Online Comment

Application H11-0389-22
Location Land at Seagate Road Long Sutton Spalding
Proposal Details of scheme to deal with contamination, construction management plan, levels, landscaping, boundary treatments, external materials and meter boxes (Conditions 3, 5, 6, 8, 9, 10 & 11 of H11-0882-21)

Name Sue Armour
Address Environmental Protection Officer SHDC

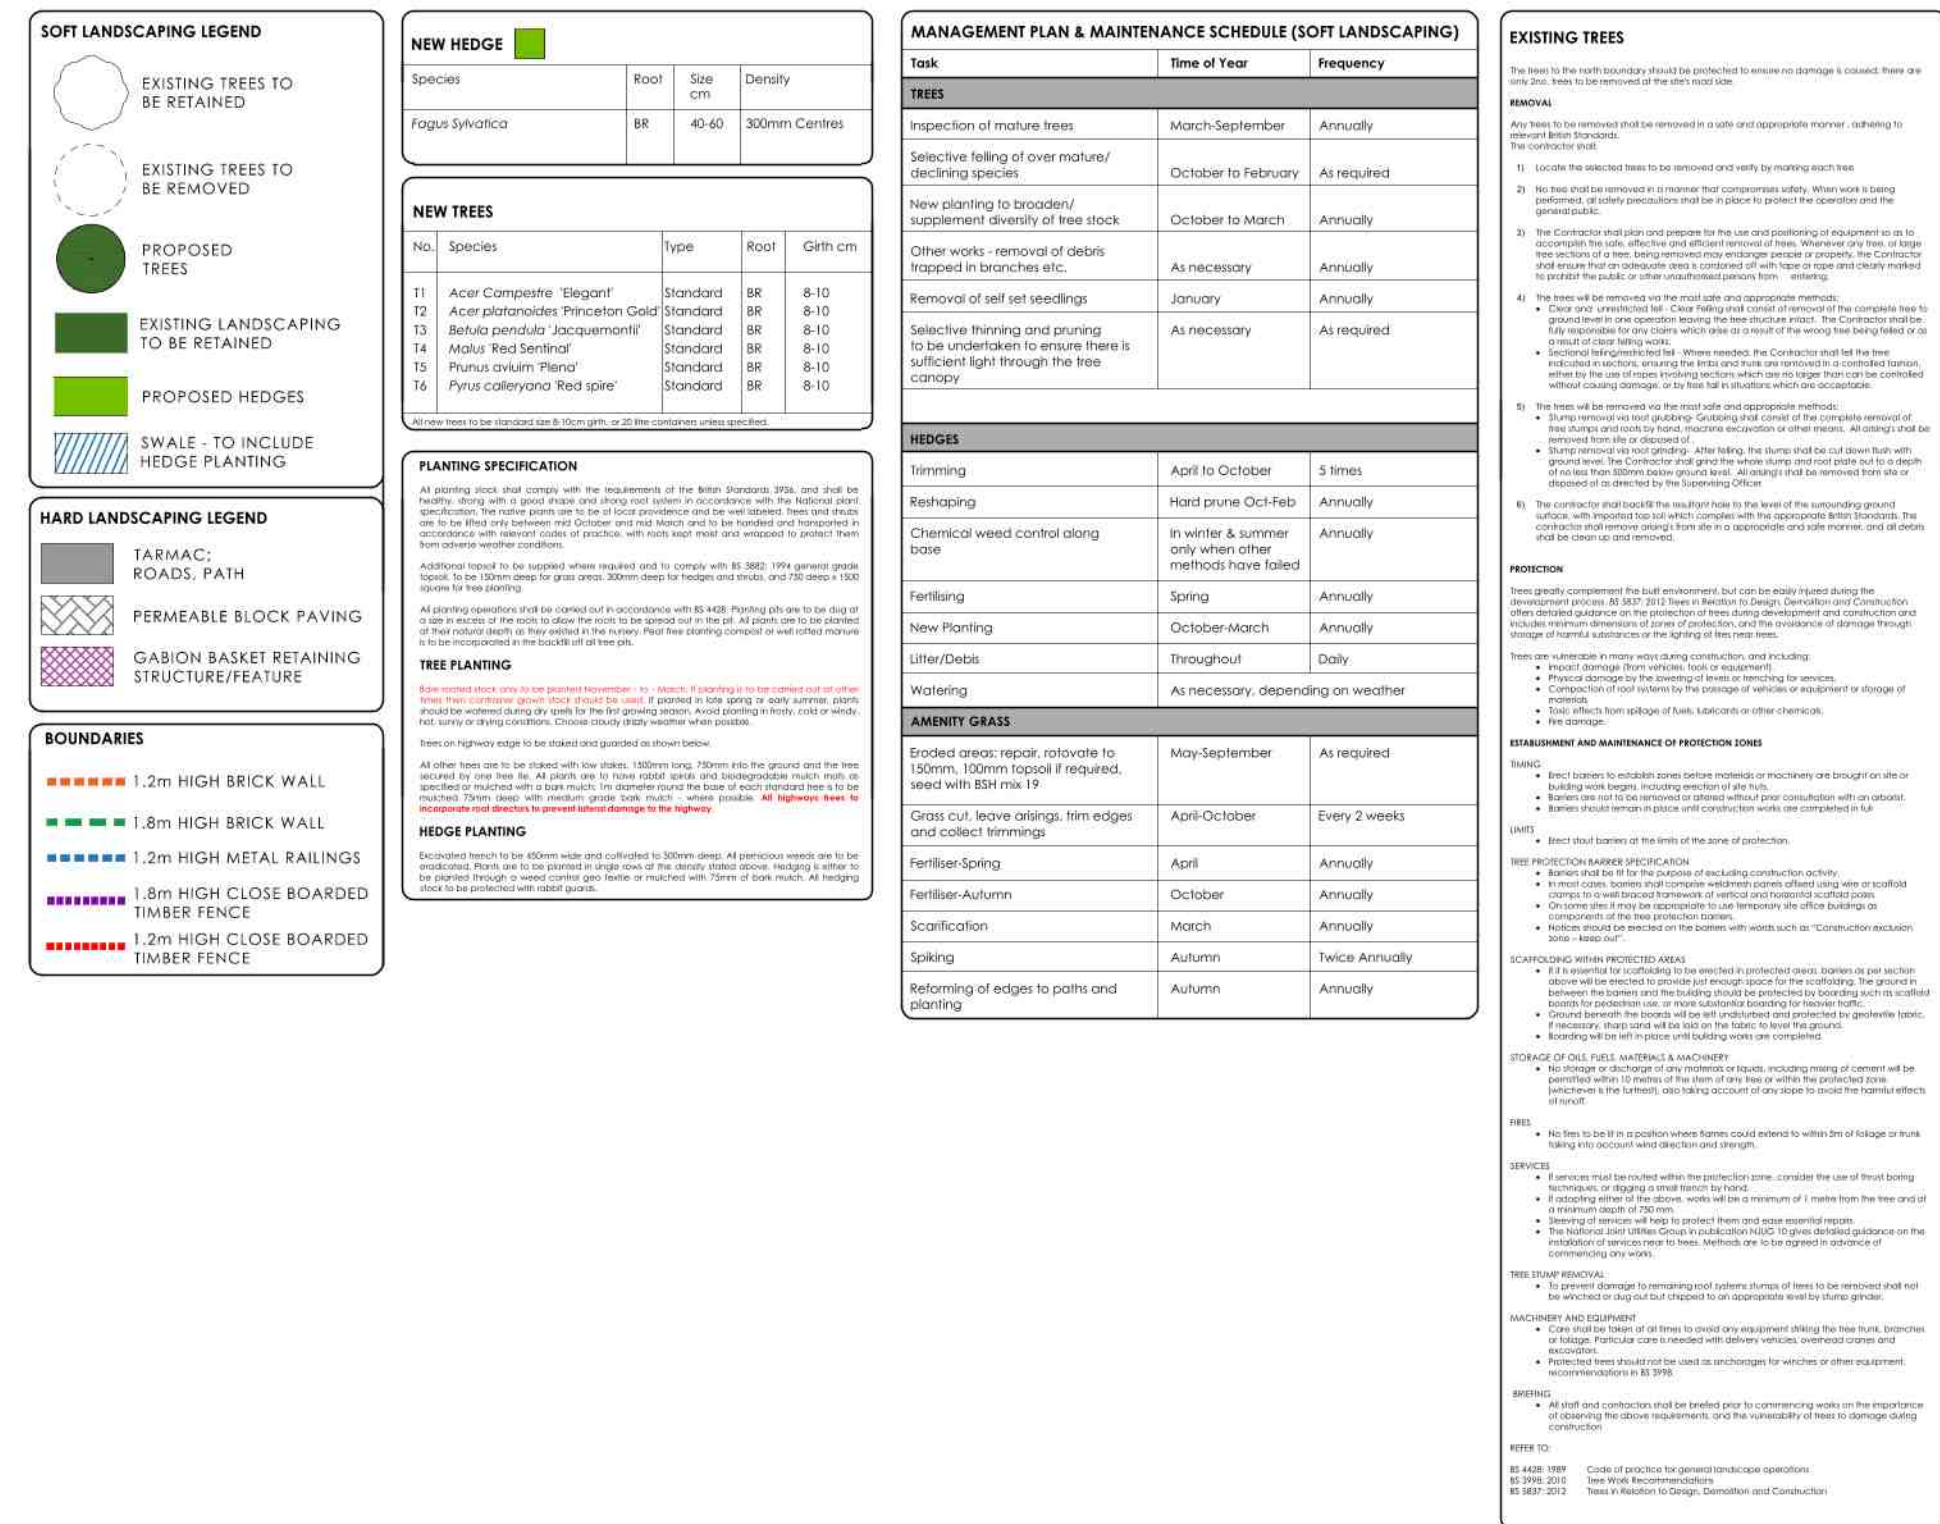
Following comments made by email dated 10/6/22 confirming that the northern part of the site will not form part of the garden to plot 1, I recommend discharge of condition 3 of H11-0882-21 in full. However, if in the future the land use of the area in question (access to easement) were to change, further consideration would be required.
